Rezoning Transportation Analysis

Petition Number: 2024-027

Reviewer: Natalie King, PE
Natalie.King@charlottenc.gov
980-417-0206

Date	Description
3-27-24	First Review (NK)

## REZONING SITE PLAN

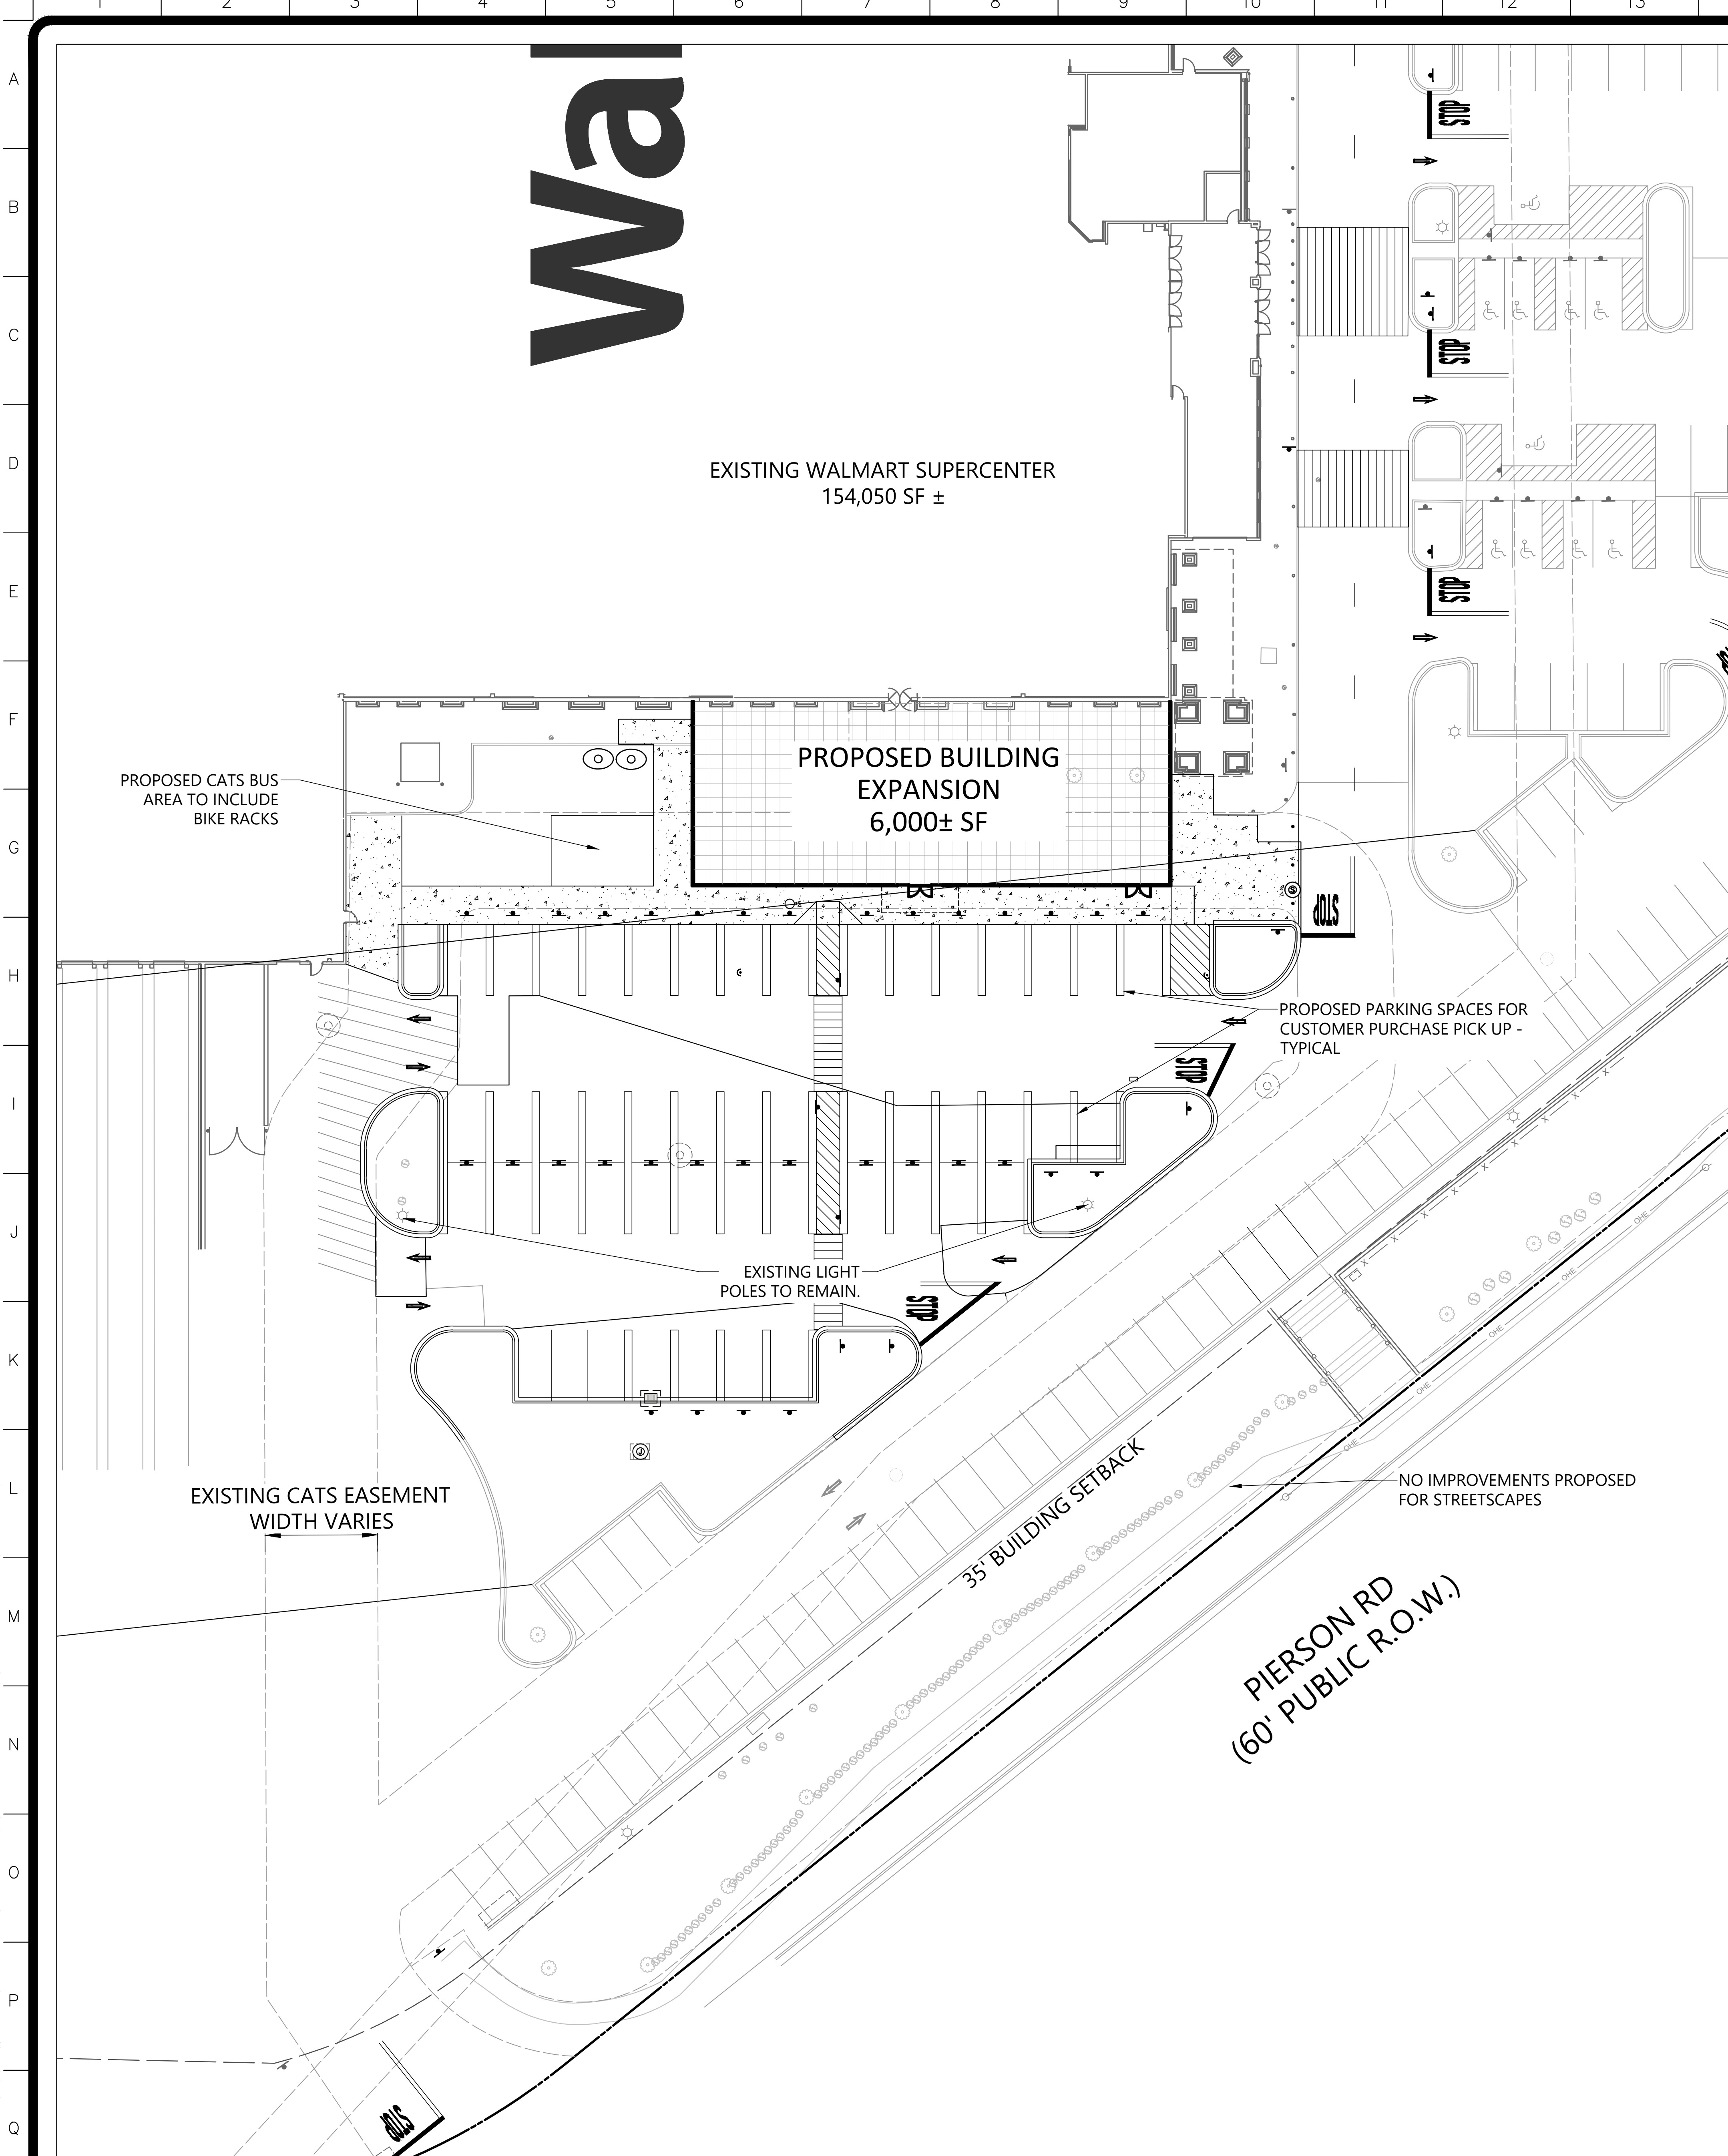
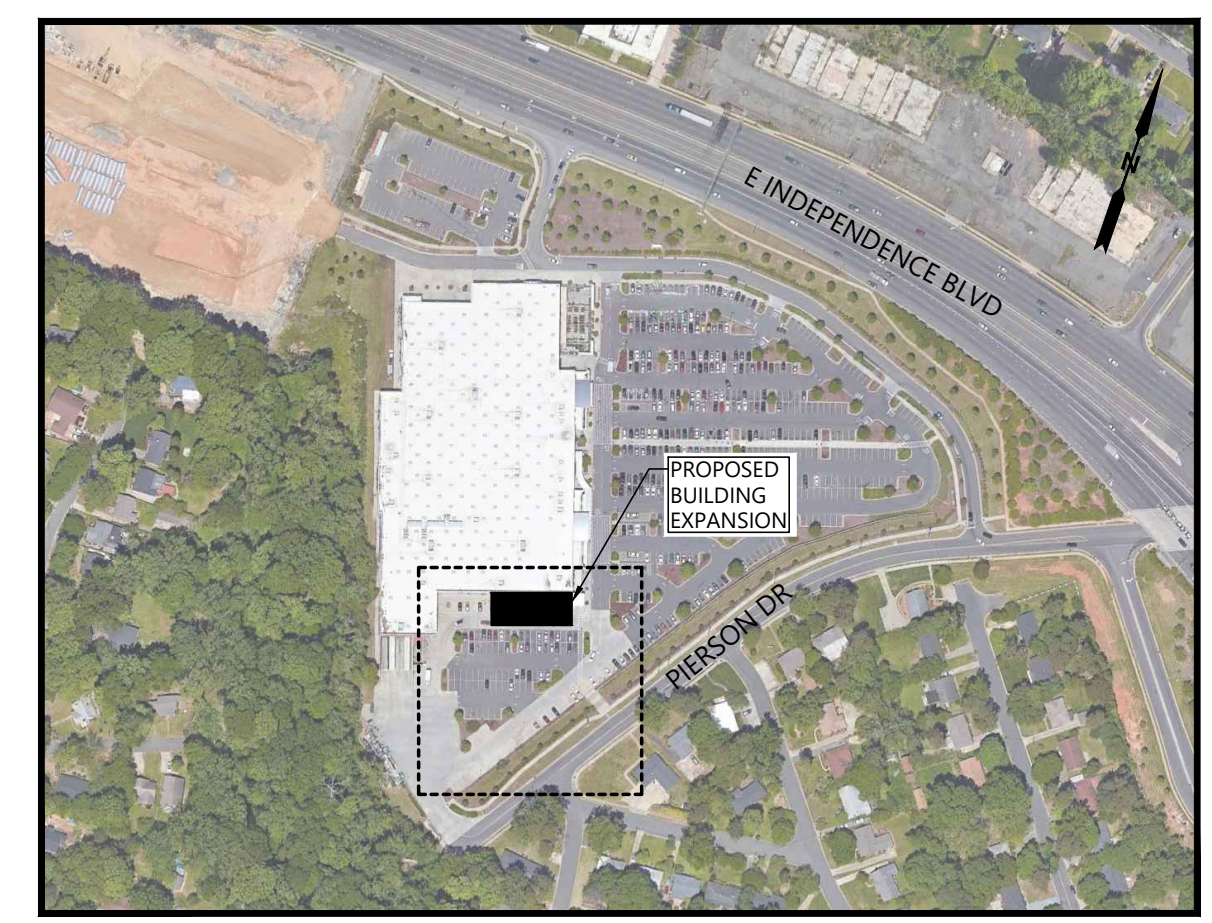
Label and dimension the curb and gutter from the centerline for each road on the site plan.

Pierson Drive: The future location of the back of curb and gutter is 17.5' from the road centerline.

Pierson Drive is a collector street with 8' planting strip and 6' sidewalk as shown in CLDSM detail U-07A.

Label and dimension the curb and gutter from the centerline for each road on the site plan.

3. Revise site plan and conditional note(s) to commit to dedicate 33.6' of right-of-way from the Pierson Drive road centerline. The site plan shall label and dimension the right-of-way from the road centerline.

5. Revise site plan and conditional note(s) to commit to installing an 8' planting strip and 6' sidewalk along Pierson Drive per UDO article 32.7.
6. Update conditional note shown below to reflect 33.6' of right-of-way from the Pierson Drive road centerline:
